Application No: AL/31/22/PL
Site Address: Ryefields Farmhouse Oak Tree Lane Woodgate PO20 3GU
Description of works: Demolition of existing building and erection of 4 no. houses with associated access, landscaping, parking and associated works. This site falls within Strategic Site SD5, CIL Zone 1 (zero rated).

Thank you for your internet representation made on 19th May 2022 which has been recorded as an objection with the comments as follows:

Objection to the above planning application, Ryefields Farmhouse, Woodgate.

Figure 1.3: Proposed Site Layout

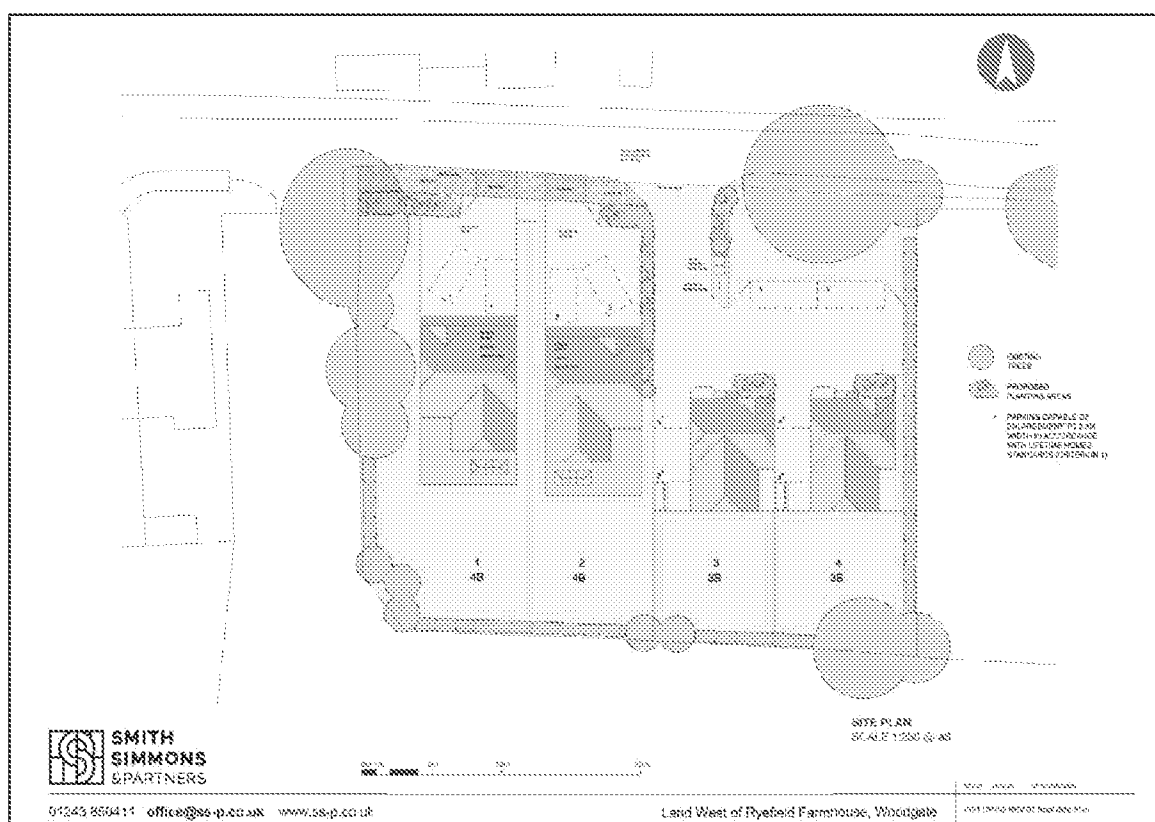
This site does not meet Building Regs., Part B Fire Safety: Approved Document B - Volume 1 Dwellings; Requirements B - Access and Facilities for Fire Service. Section 13: Vehicle Access, Diagram 13.1 and Table 13.1. Which states that "Fire and rescue service vehicles should not have to reverse more than 20m from the end of an access road". To get to the site entrance a fire engine would have to reverse a considerable distance and would not be able to turn onto the site itself. Not only does the lane narrow to 3m, but access is via a privately owned gravel track that is prone to flooding. In the event of a fire it would need to either reverse all the way up from the green, or reverse all the way out from Reeds Lane. The distance between the green and the site entrance is more than 130m or 100m up to the start of Reeds Lane, whilst negotiating parked cars. Side note: the Woodgate Centre, which currently serves as a turning point for most vehicles, will not be in use for this purpose in the future as it has its own planning application for a new estate that will back onto the end of Reeds lane end; that effectively leaves the dead end without a turning area at all.

FIGURE 1.6

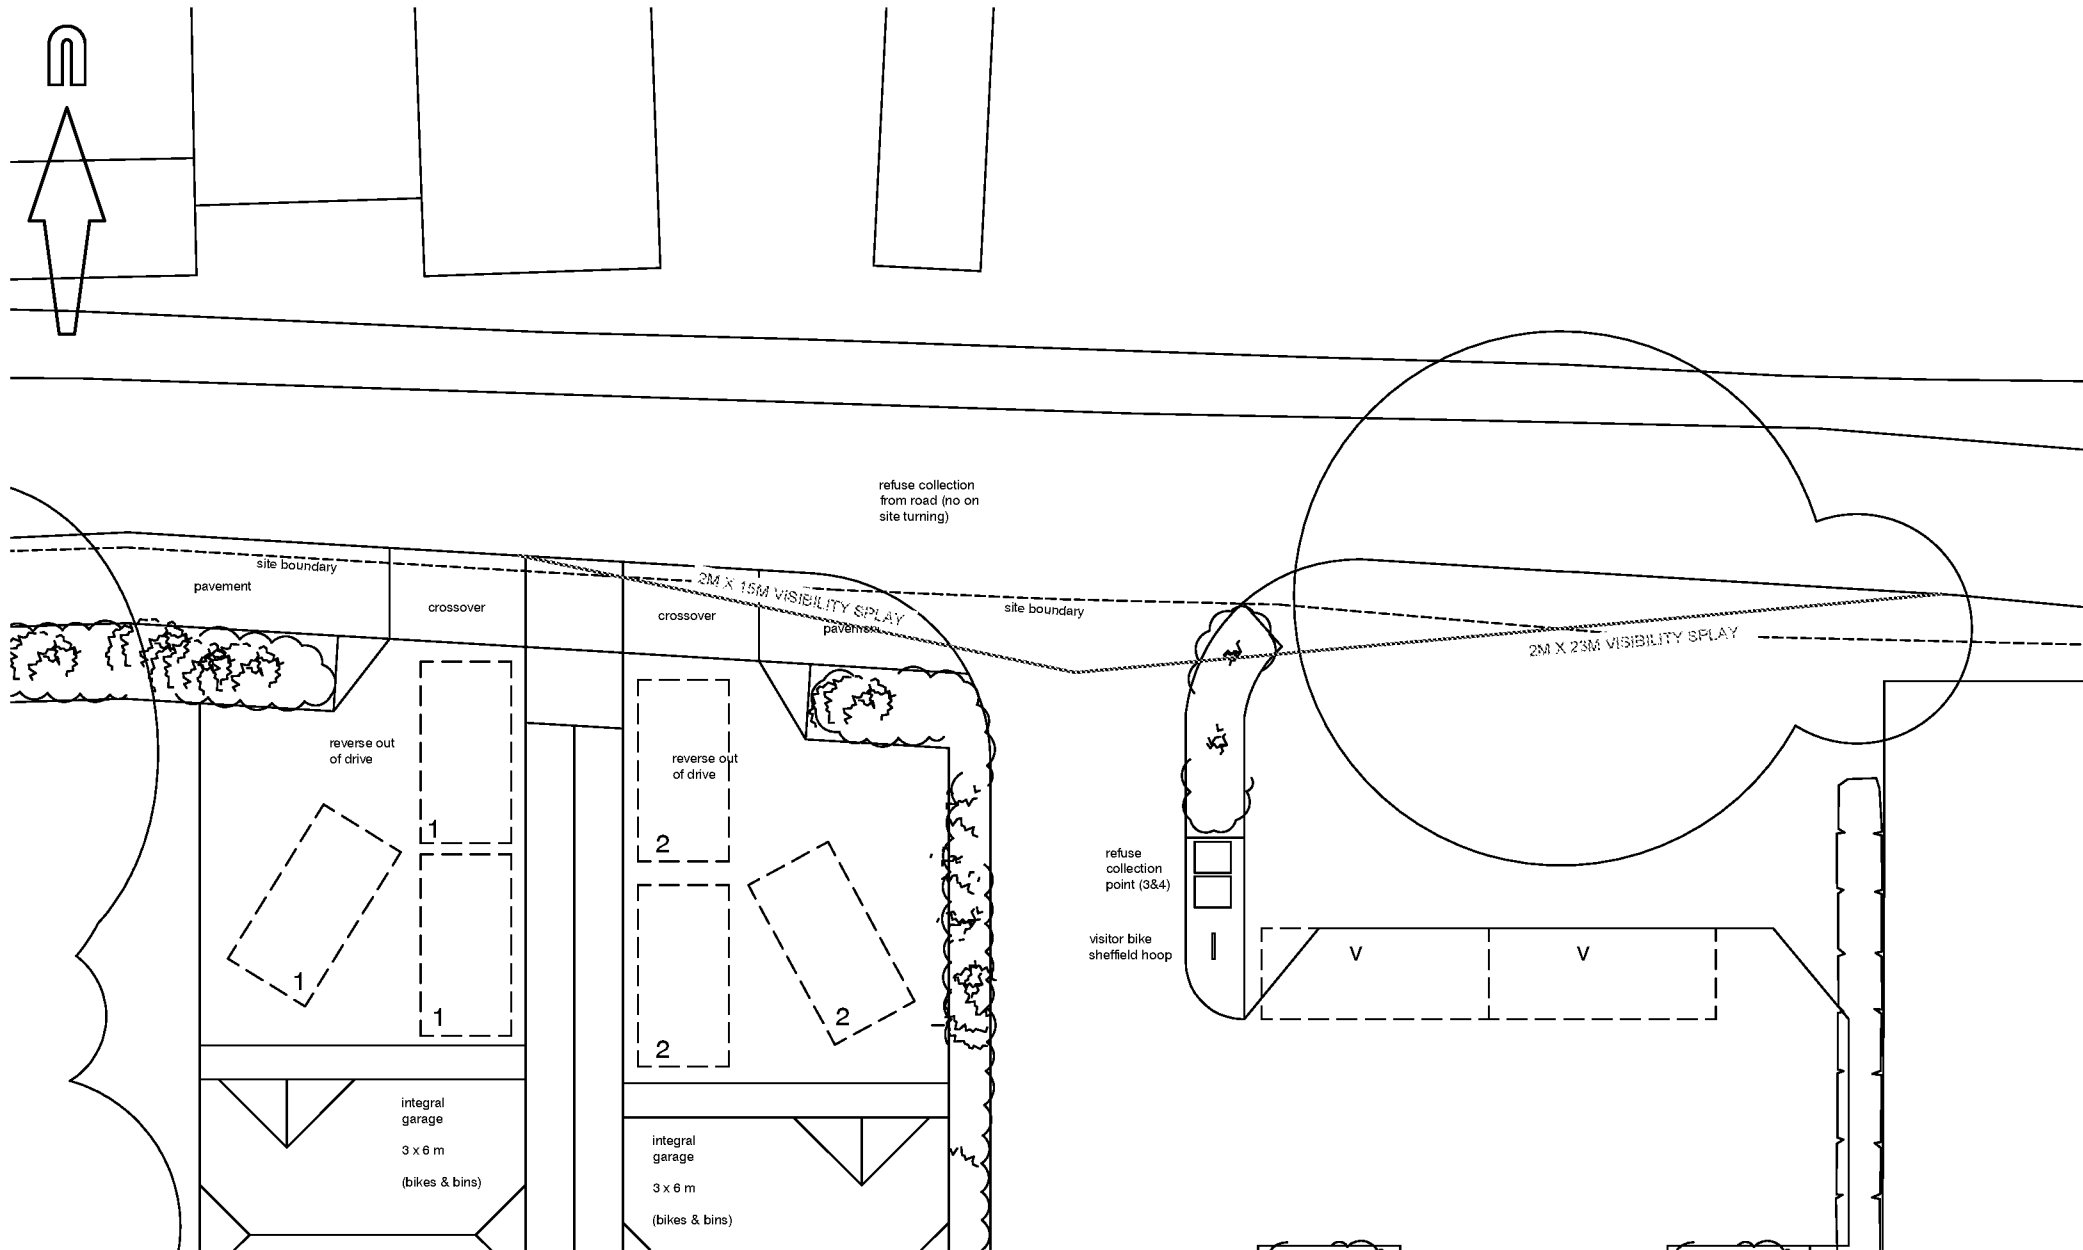
Regards to the new footpath; this encroaches beyond the site boundary, into the lane itself, making the lane even narrower, further restricting access and does not tie in to the existing footpath being disconnected by 10m approx. At some point pedestrians would have to traverse an unmade up section in order to reach the next path. Refuse collection at the Reeds Lane already requires a smaller truck as the one that services the rest of Oak Tree Lane cannot fit down it and also has to reverse all the way up from the green as it cannot turn elsewhere. The parking is also not adequate for 4, 3 & 4 bed houses. The two visitor parking spaces will undoubtedly be taken up by residents, then what? Re. photo board (still incorrect). Images 1, 2 & 3 are not

aligned with the icons positioned on the map and do not give a proper representation of the visibility from the site as they were not taken from the site access. If this feature is to be used, it could at least be right.
